**From:** Andersen, Linda <Linda.Andersen@lancashire.gov.uk>  
**Sent:** 16 April 2019 17:22  
**To:** planning  
**Subject:** Lancashire County Council - Public Right of Way response to planning app 3/2019/0239  
**Attachments:** 3-2019-0239 PROW response.pdf  
**Follow Up Flag:** Follow up  
**Flag Status:** Completed  
**Categories:** Yellow Category

### **Consultation on planning application 3/2019/0239 Hall Barn Farm, Knowles Brow, Hurst Green BB7 9PT**

Location Plan

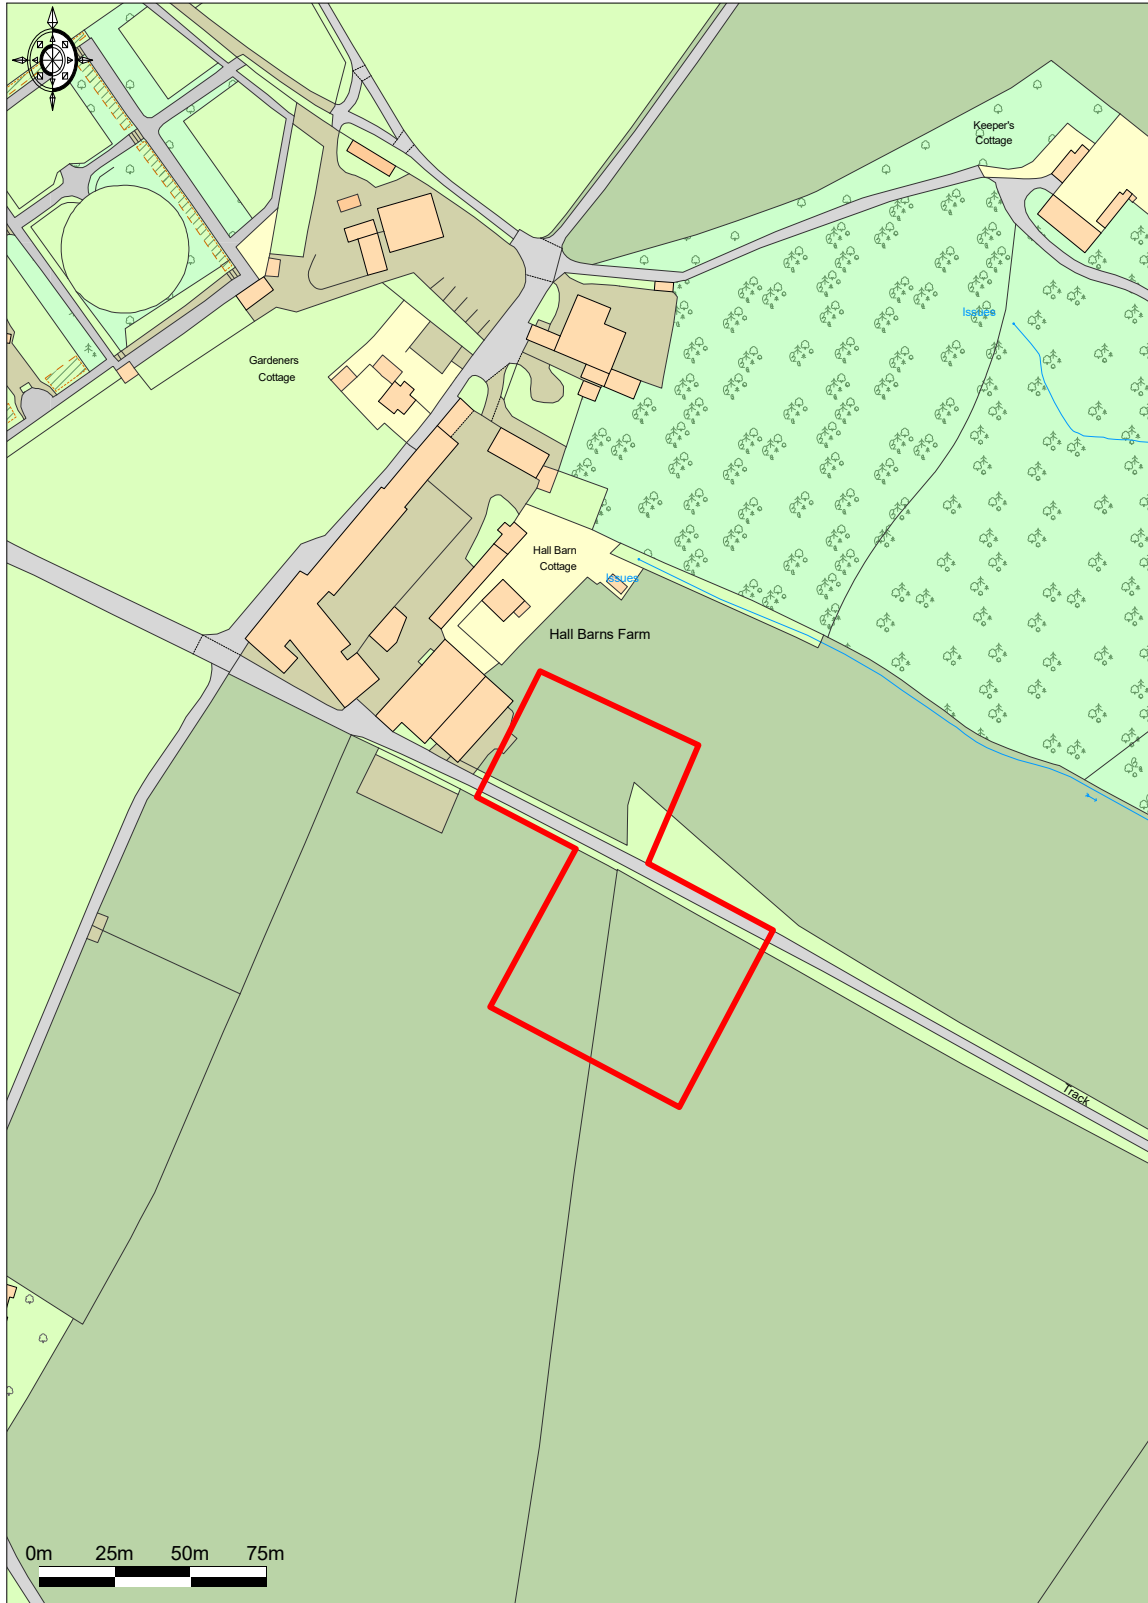
Thank you for the opportunity of commenting on planning application 3/2019/0239 I have identified (see attached plan) that the site in question crosses Public Right of Way 3-3-FP63 and the following needs to be taken into account when considering this application. As the application stands I would raise an objection to the application subject to responses to the following;-

- If the intention is to build over the public right of way a certified diversion order would be required prior to works commencing.
- If the application is successful and works would impact on users of the public right of way a temporary closure would need to be applied for prior to commencing work.

- It is not clear from the application whether vehicular access will be increased or if there are private rights attached to the site concerned as the footpath is for pedestrians only. Increased vehicular access would pose a danger to users and impact on the surface of the footpath increasing maintenance responsibilities.

PLAN VIEW - SCALE 1:200

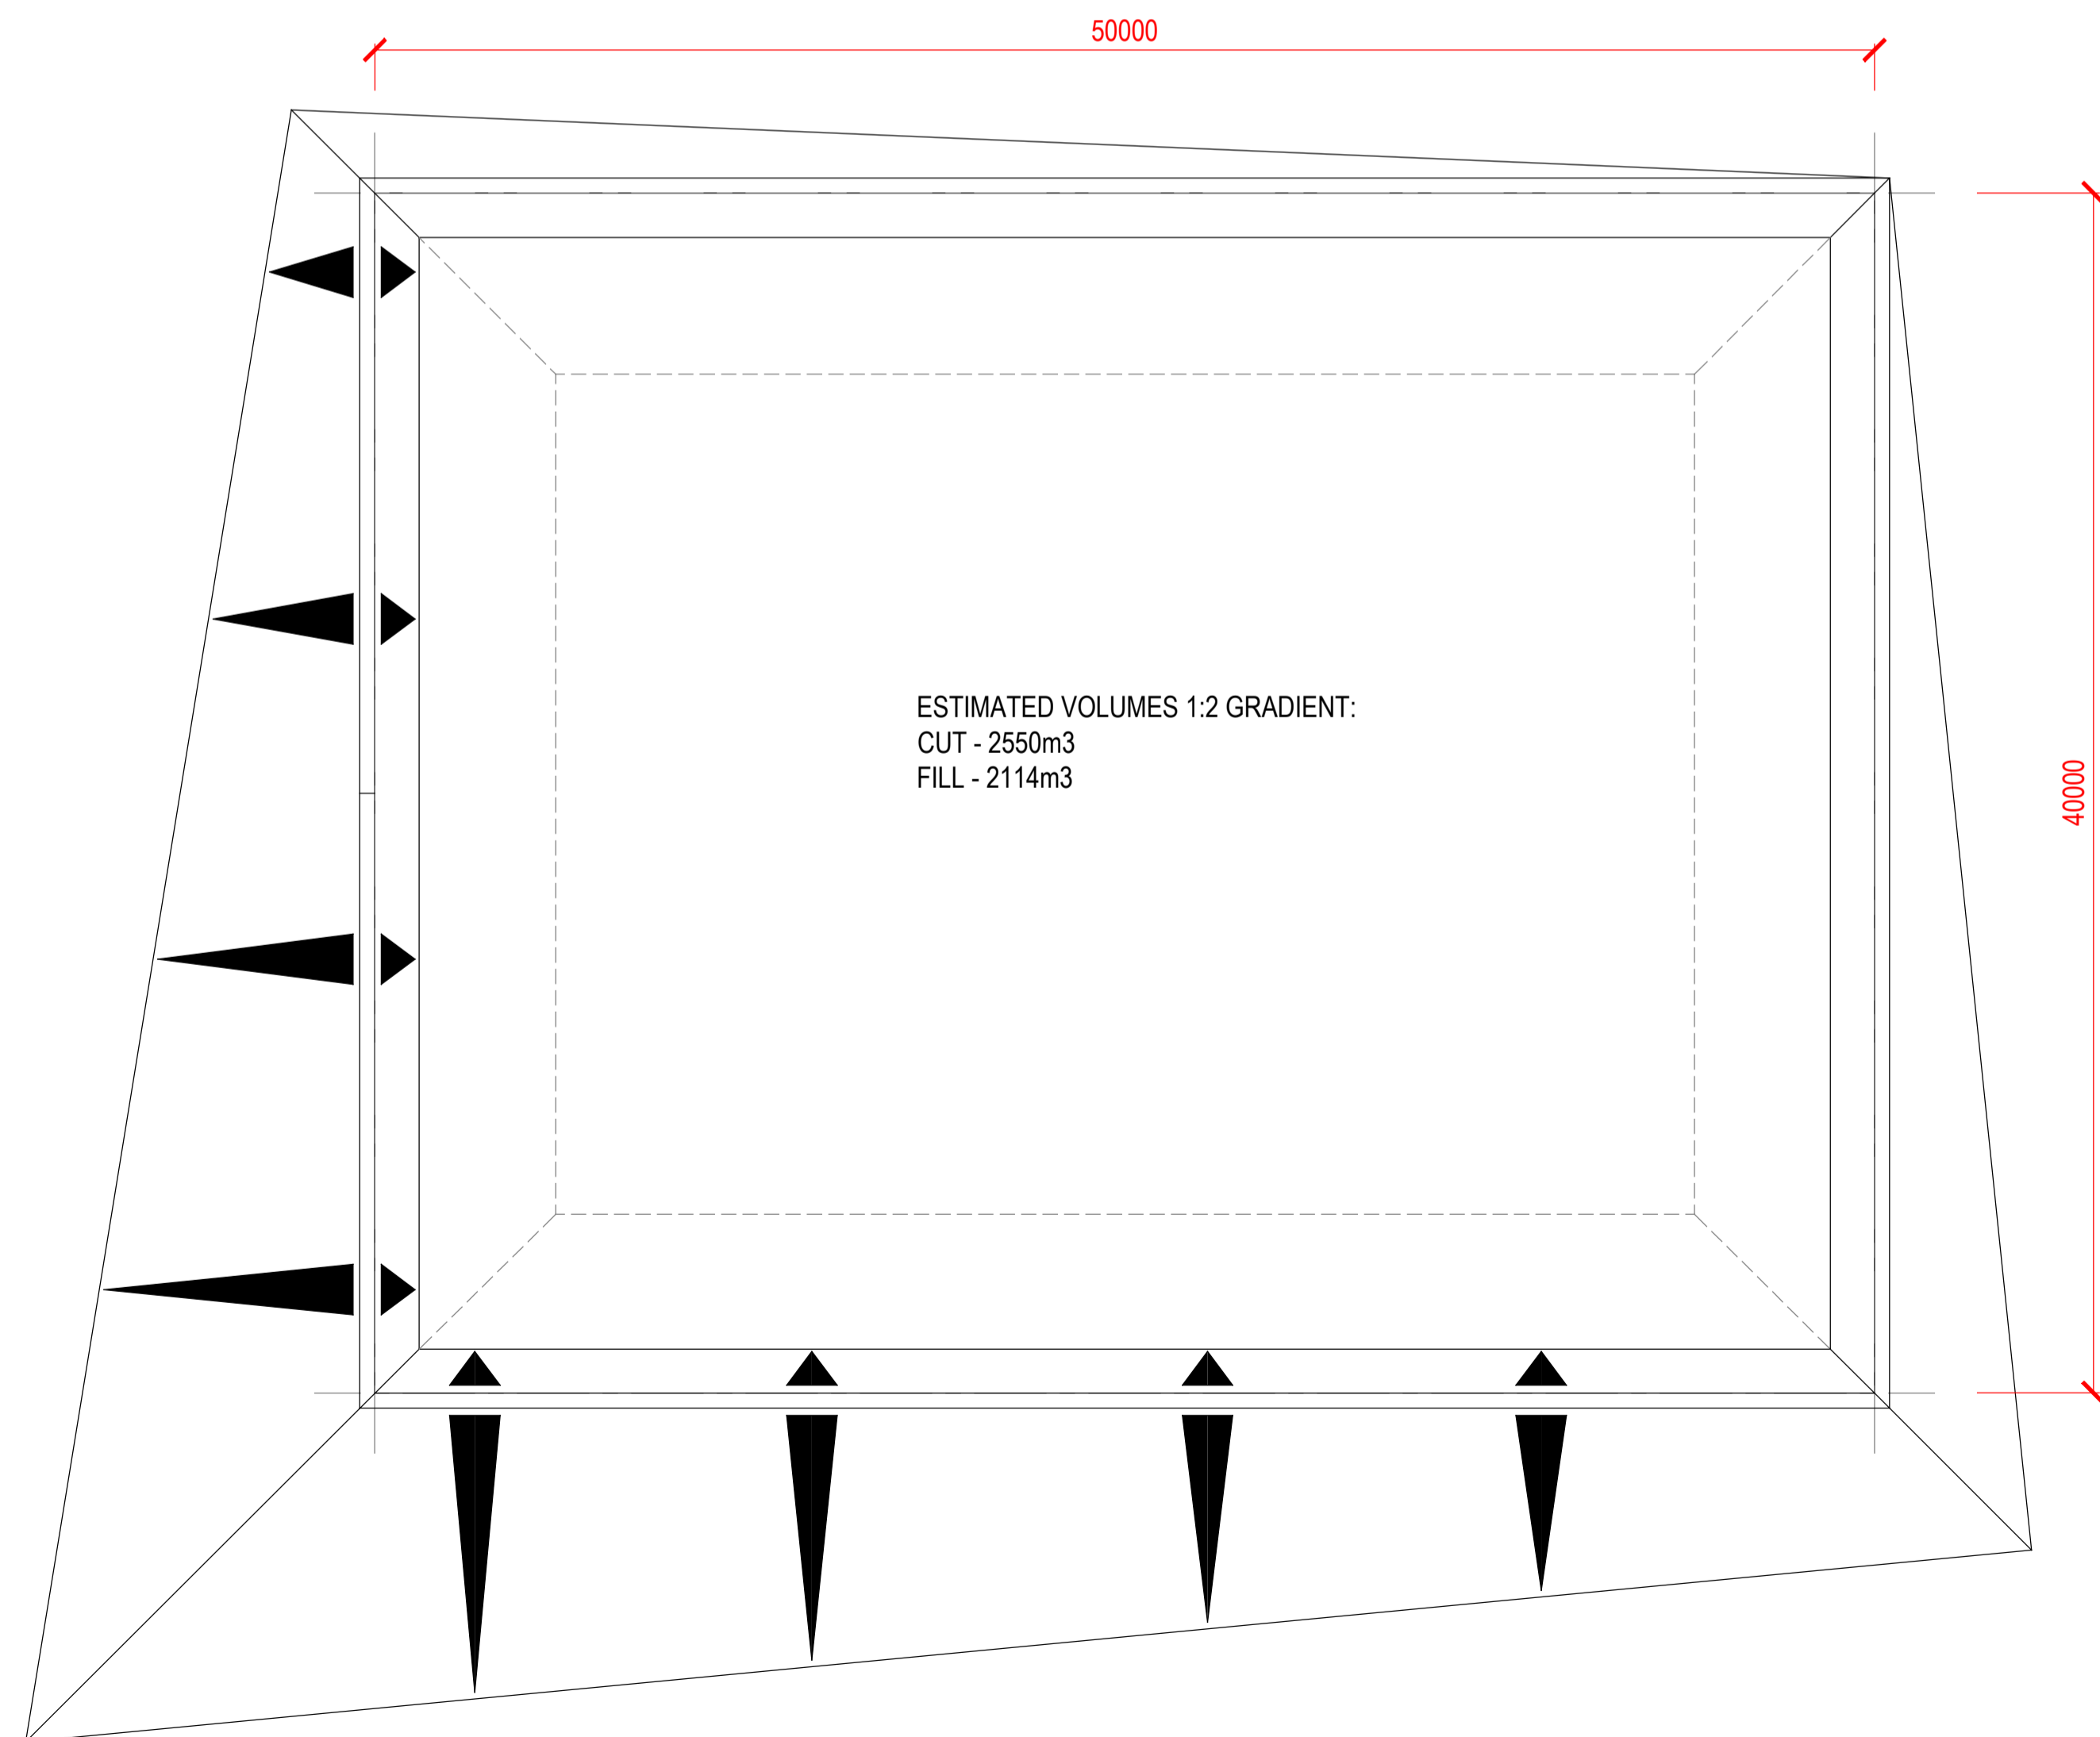
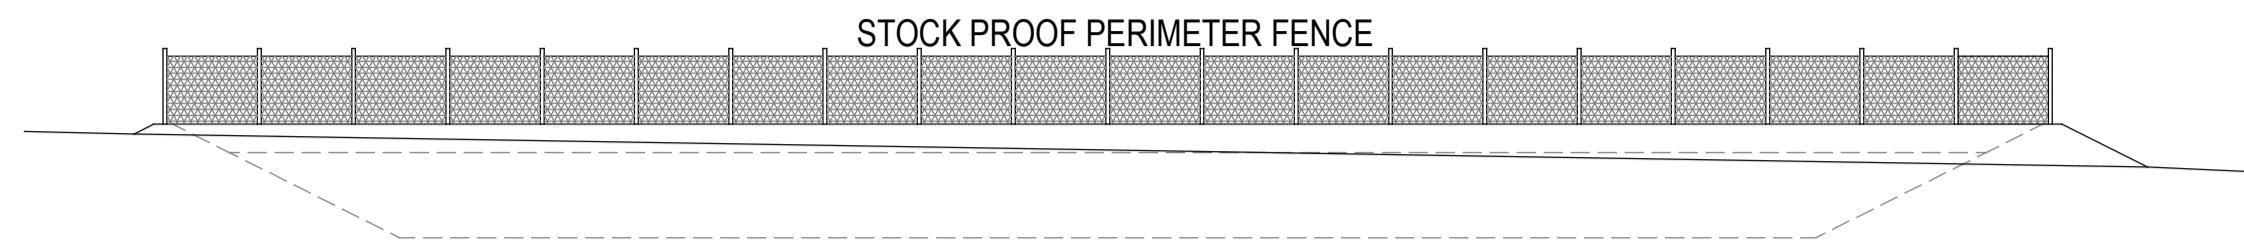
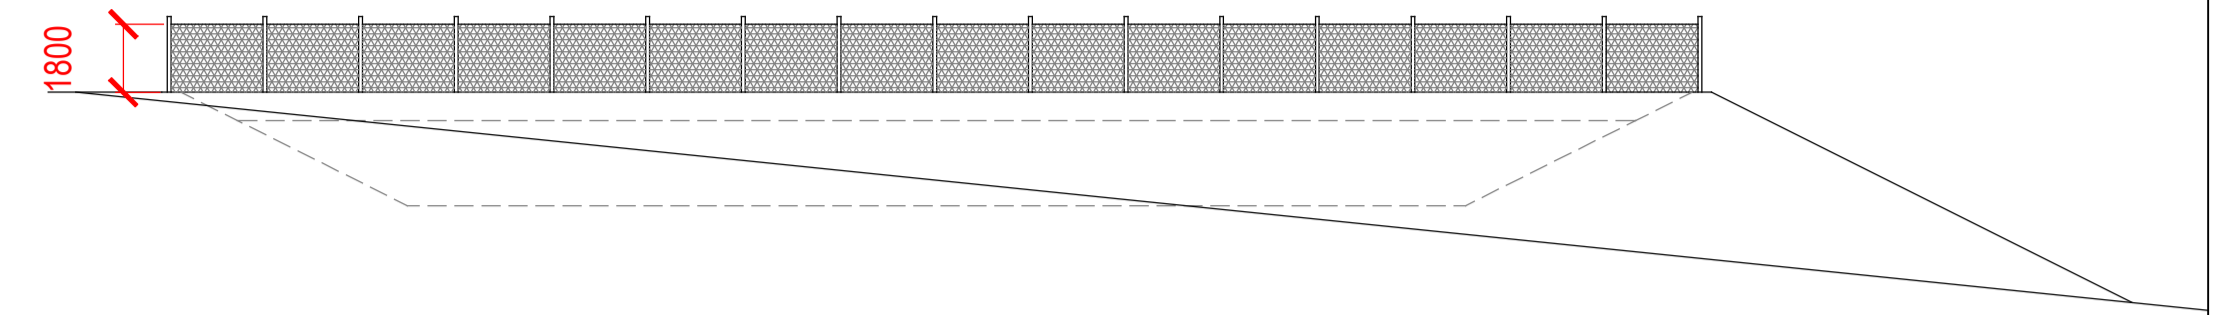
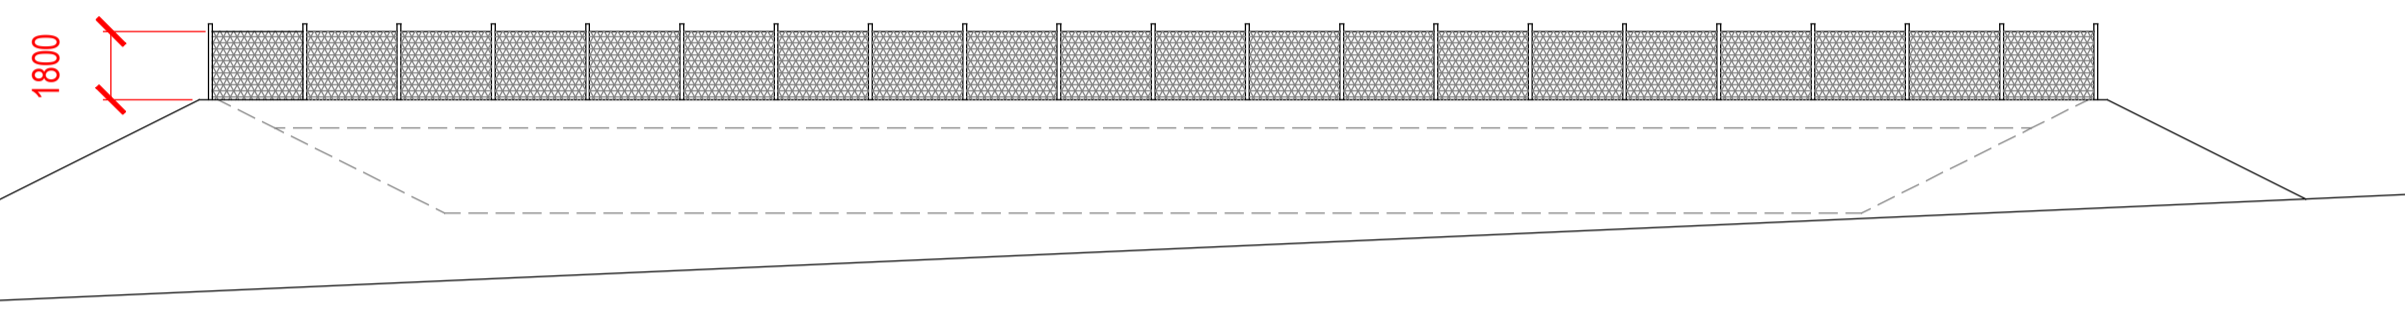
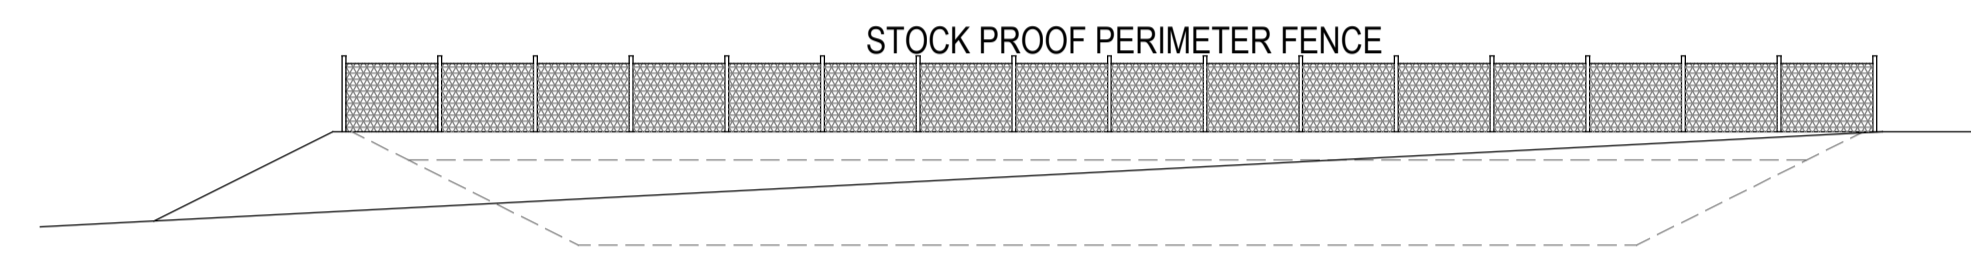
- Raising the ground level and surface water drainage can impact on the potential flooding of a public right of way and this should be taken into account particularly in relation to the drainage.

- More information would be required in relation to the nature of the slurry pit e.g. will the location of the public right of way be subject to unpleasant smells as a result subsequently putting users off using the Right of Way.
